DEVELOPMENT REVIEW BOARD
TRANSPORTATION DEVELOPMENT

DRB Project Number: 1001990 / 1002229
Tannehill Taylor Addition

SUBJECT: Sketch Plat

DATE: April 11, 2018

PLAT OF  
 TRACTS A-1-A AND A-2-A  
 TANNEHILL-TAYLOR ADDITION

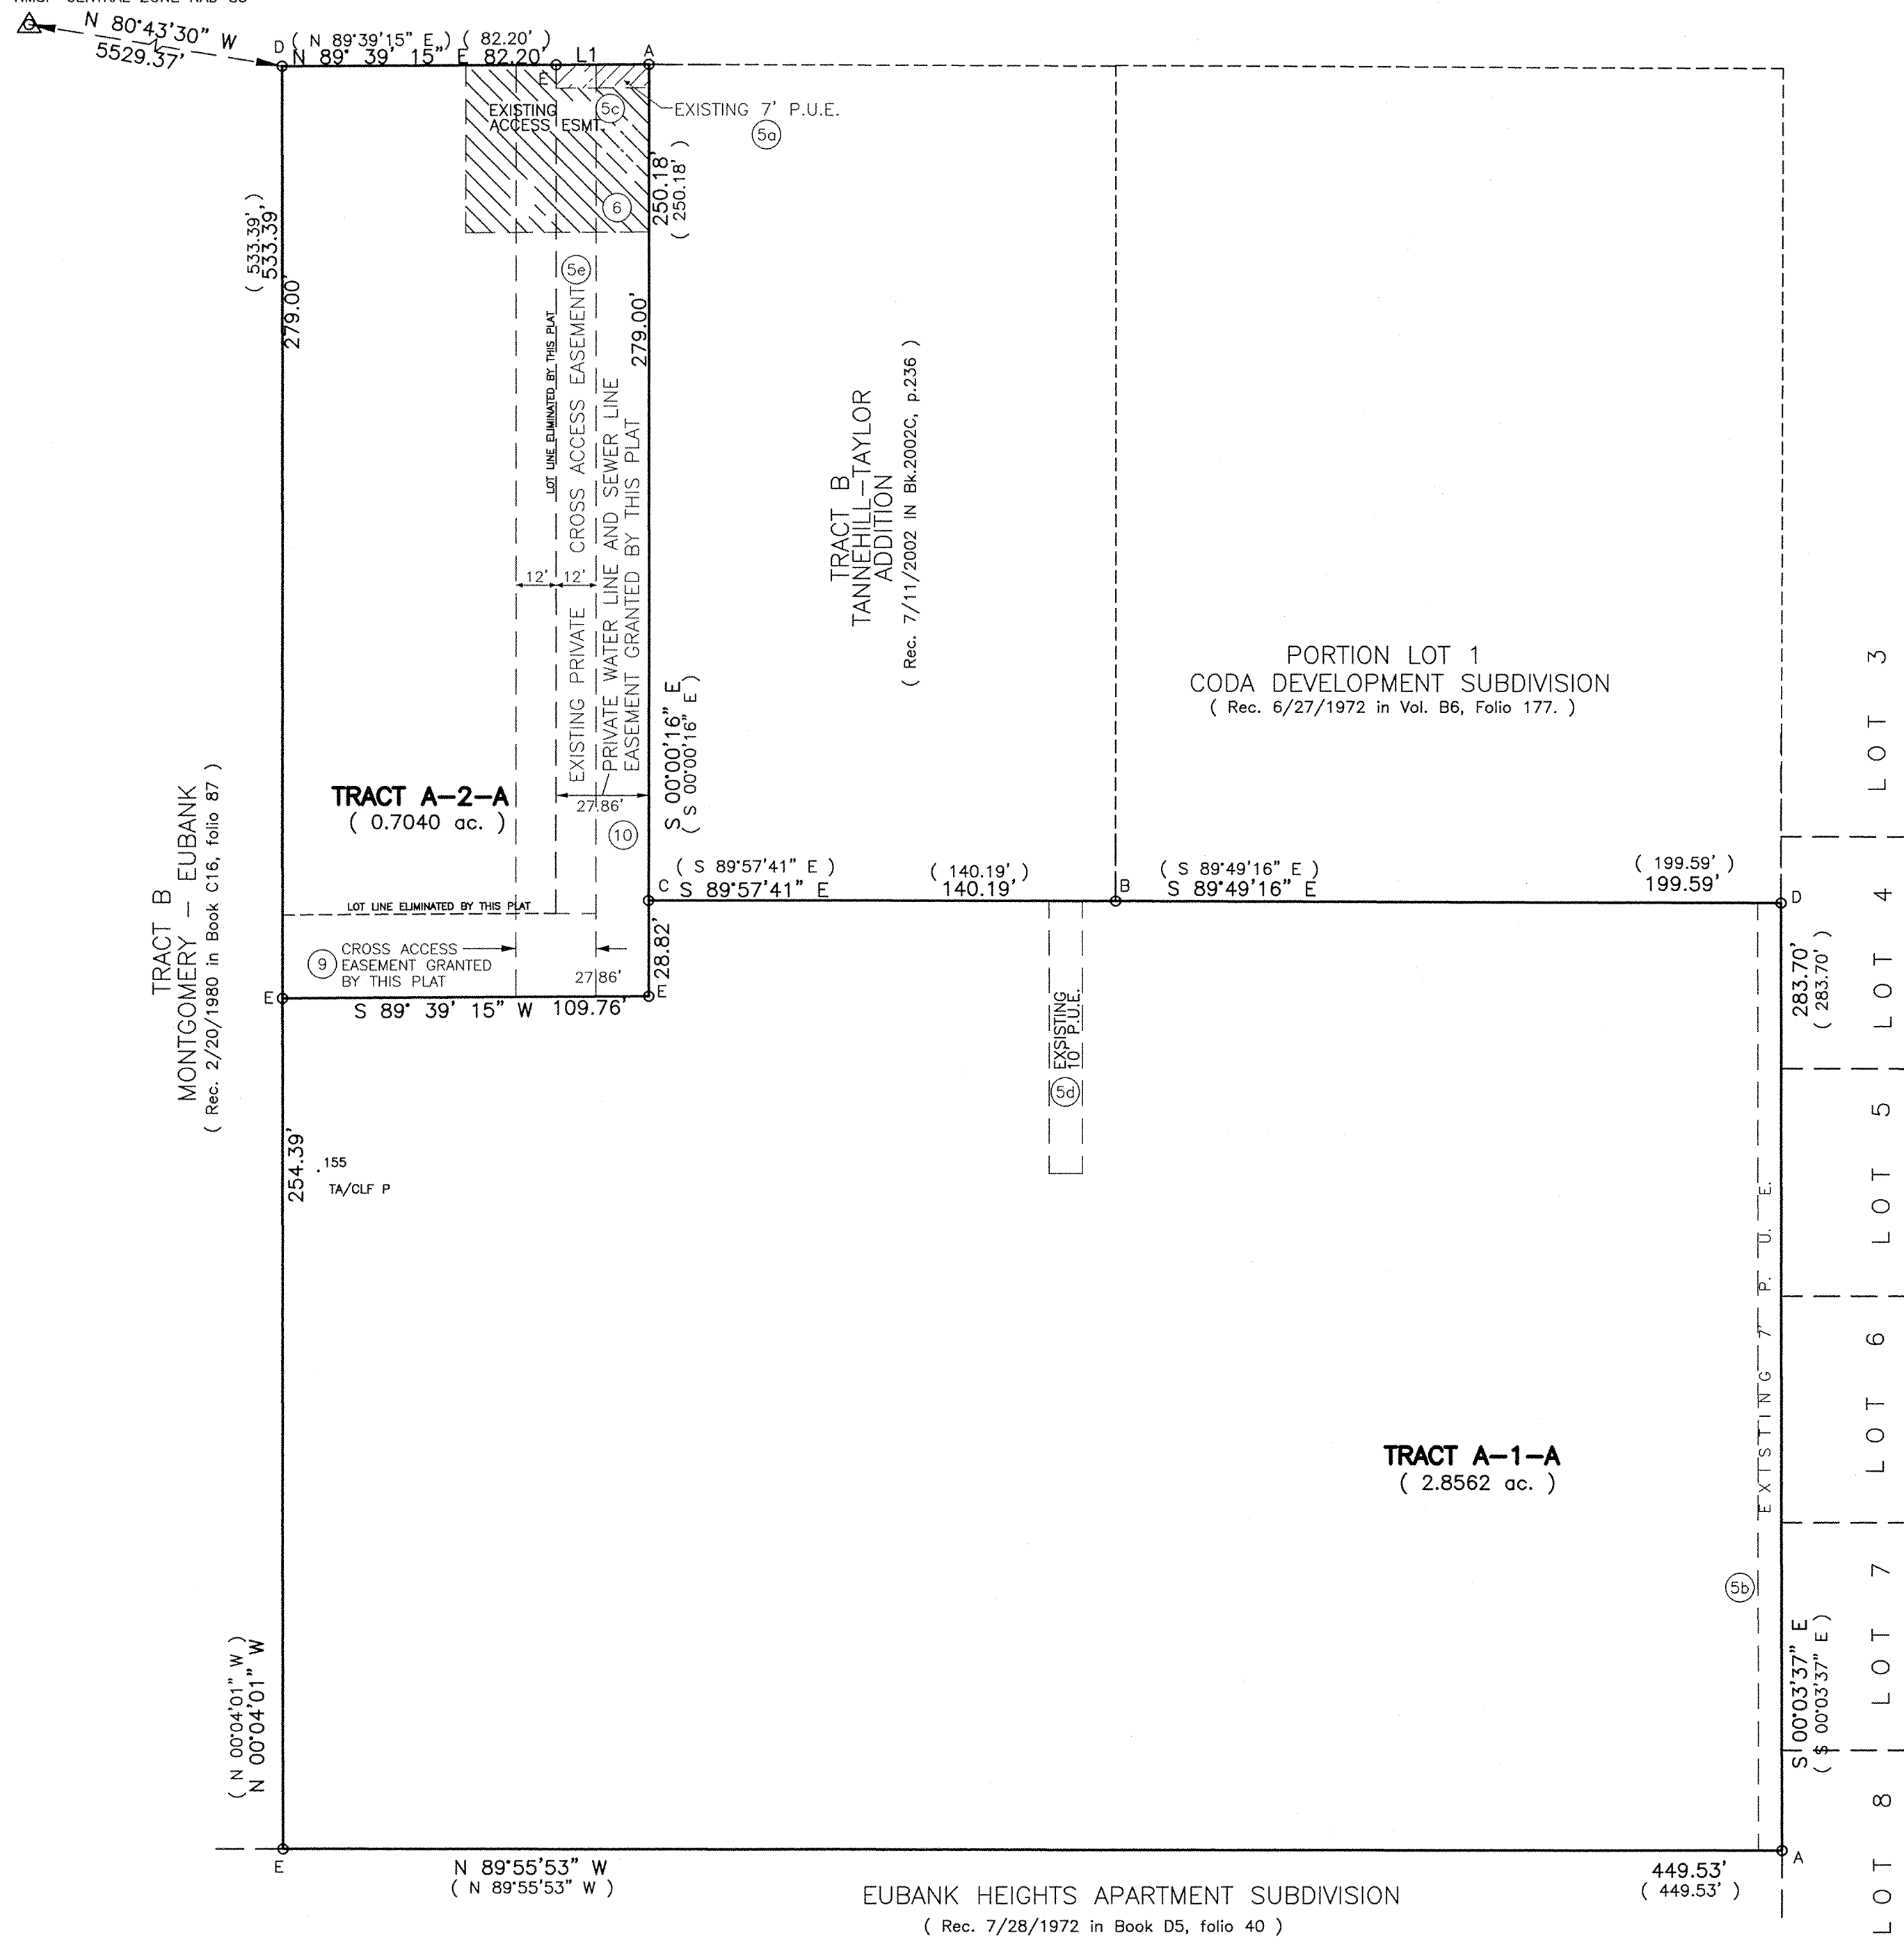
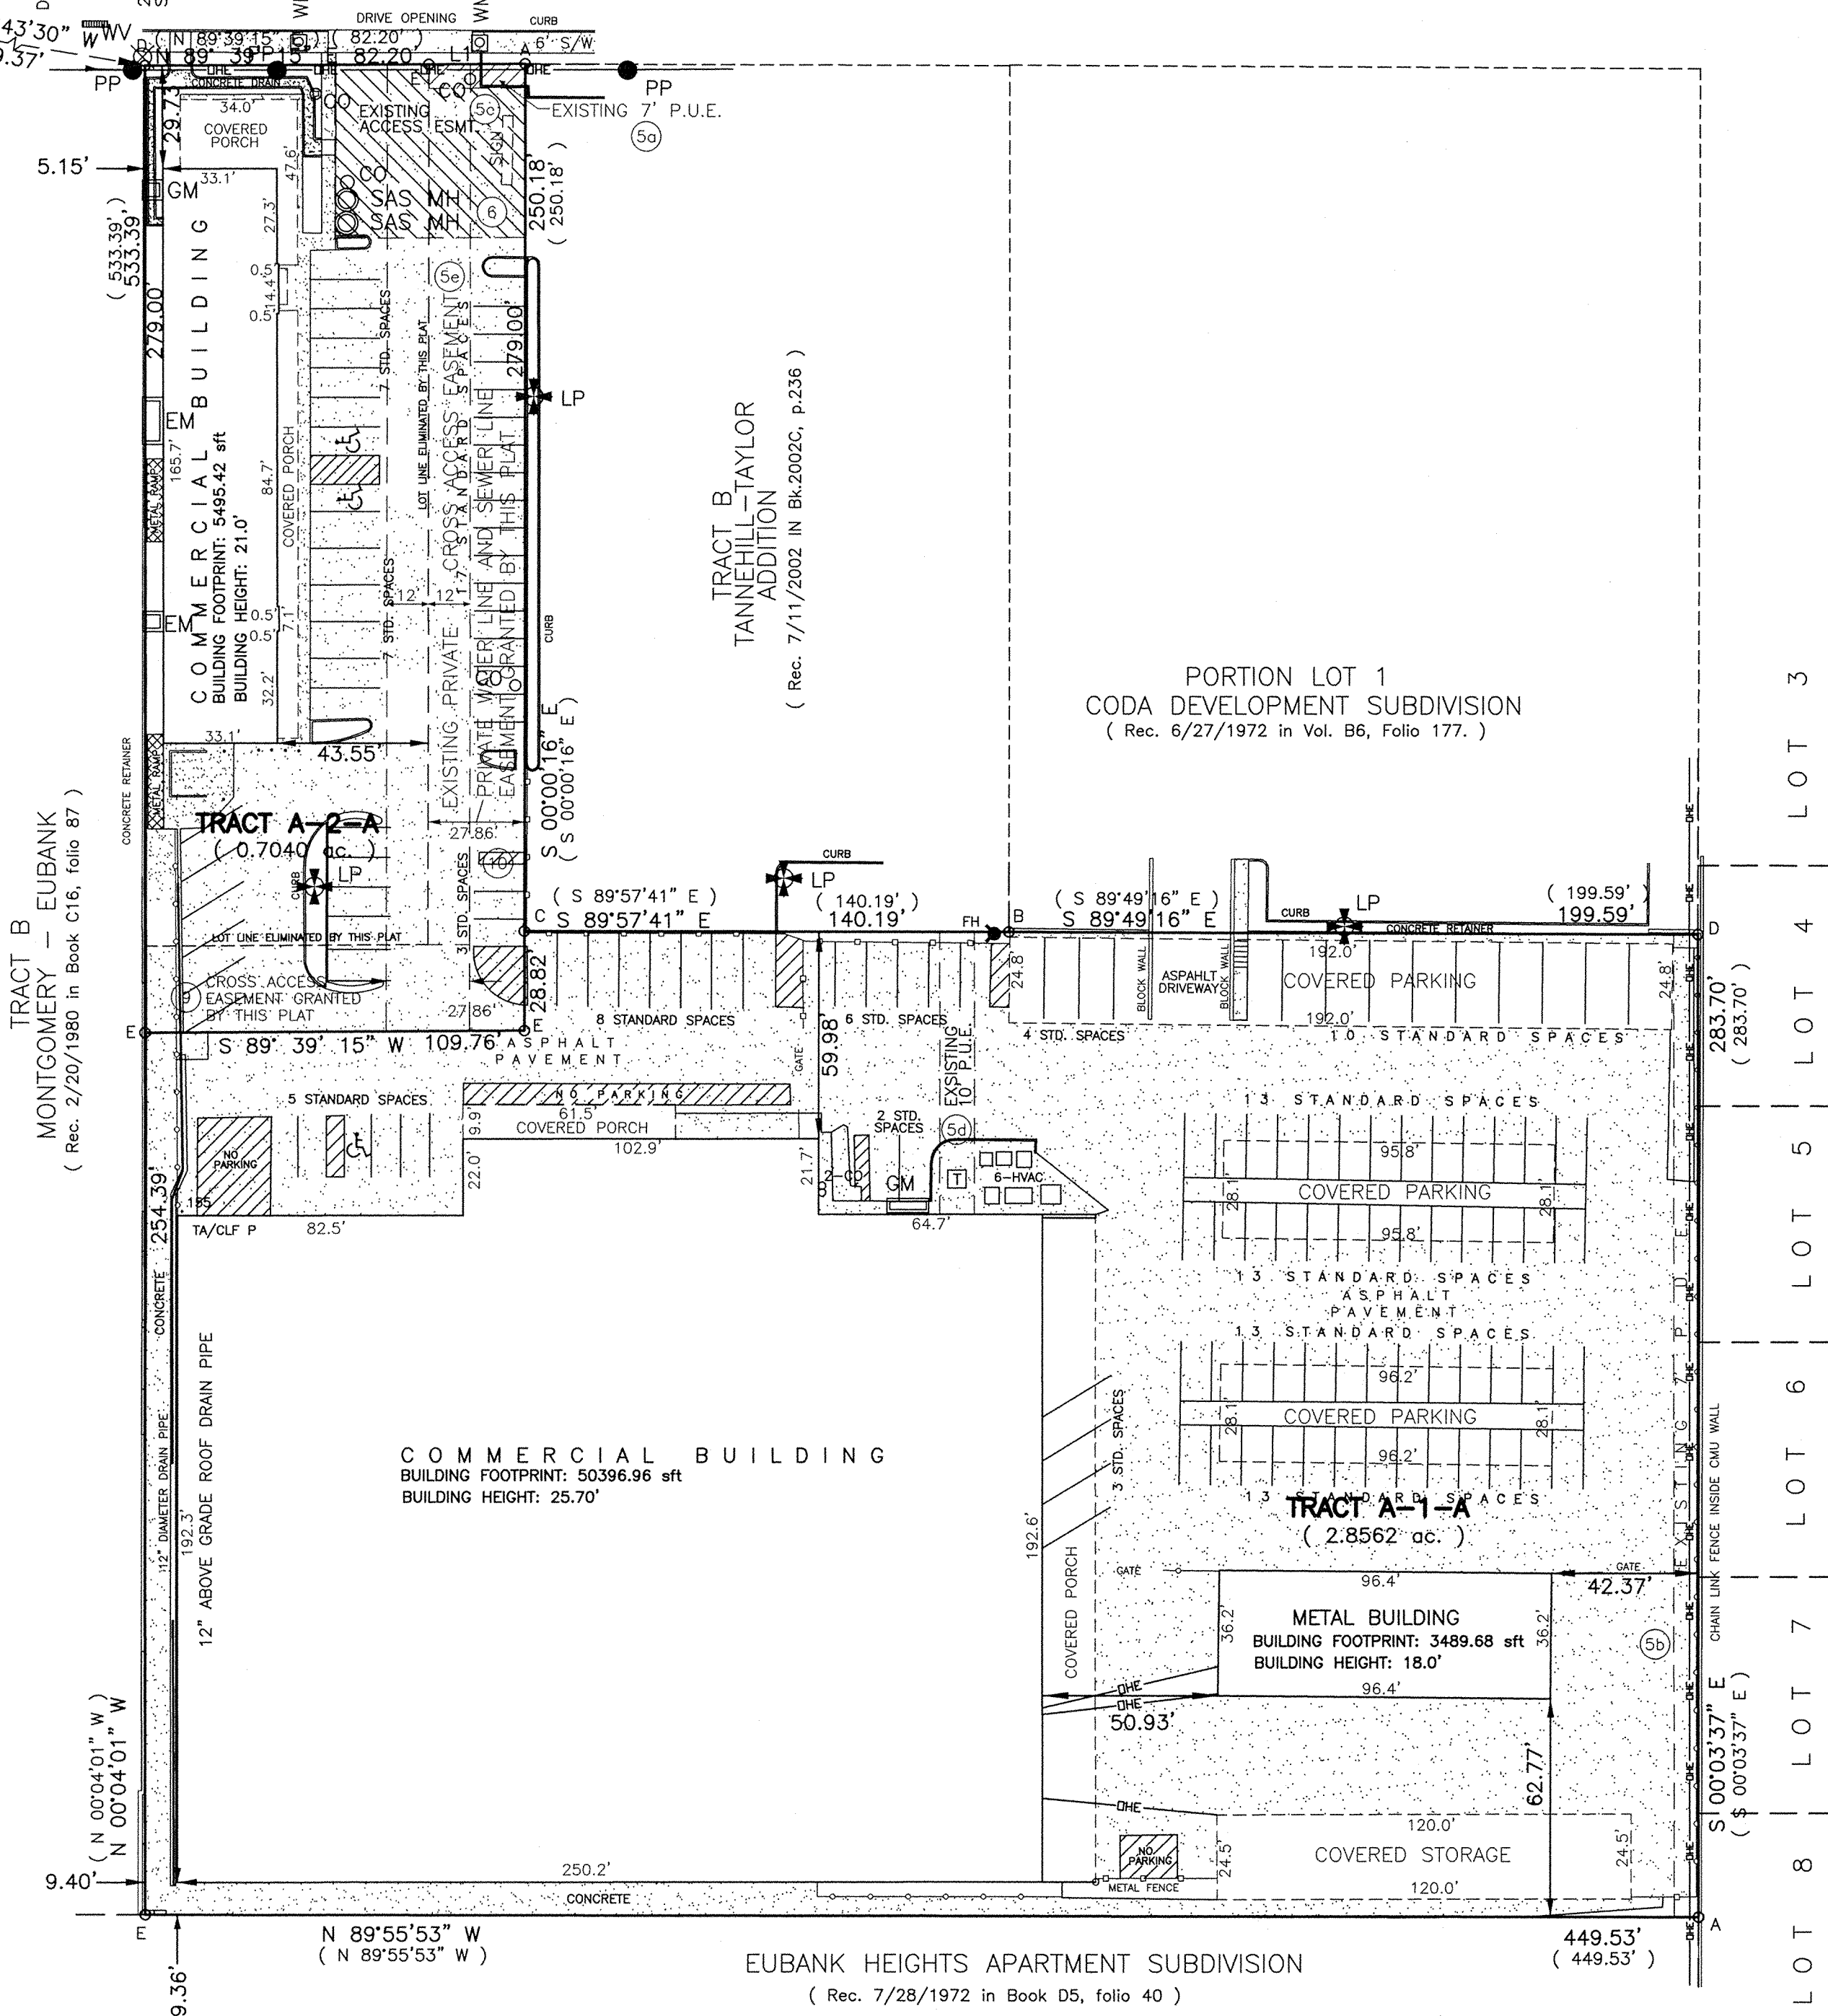
1. There is access between tract A-2-A and tract B. Provide an easement.
2. For final plat, any access easements need to be shown with all beneficiaries and maintenance responsibilities listed.
3. Please include a copy of your access agreements.

The west lot line that separates the existing two tracts is also a zone boundary. That must be clearly labelled on the plat.

The EPC staff report states that there are existing cross lot access and parking agreements in place. Submit a copy with the subdivision plat application. If they are not up to date, then new ones will be required.
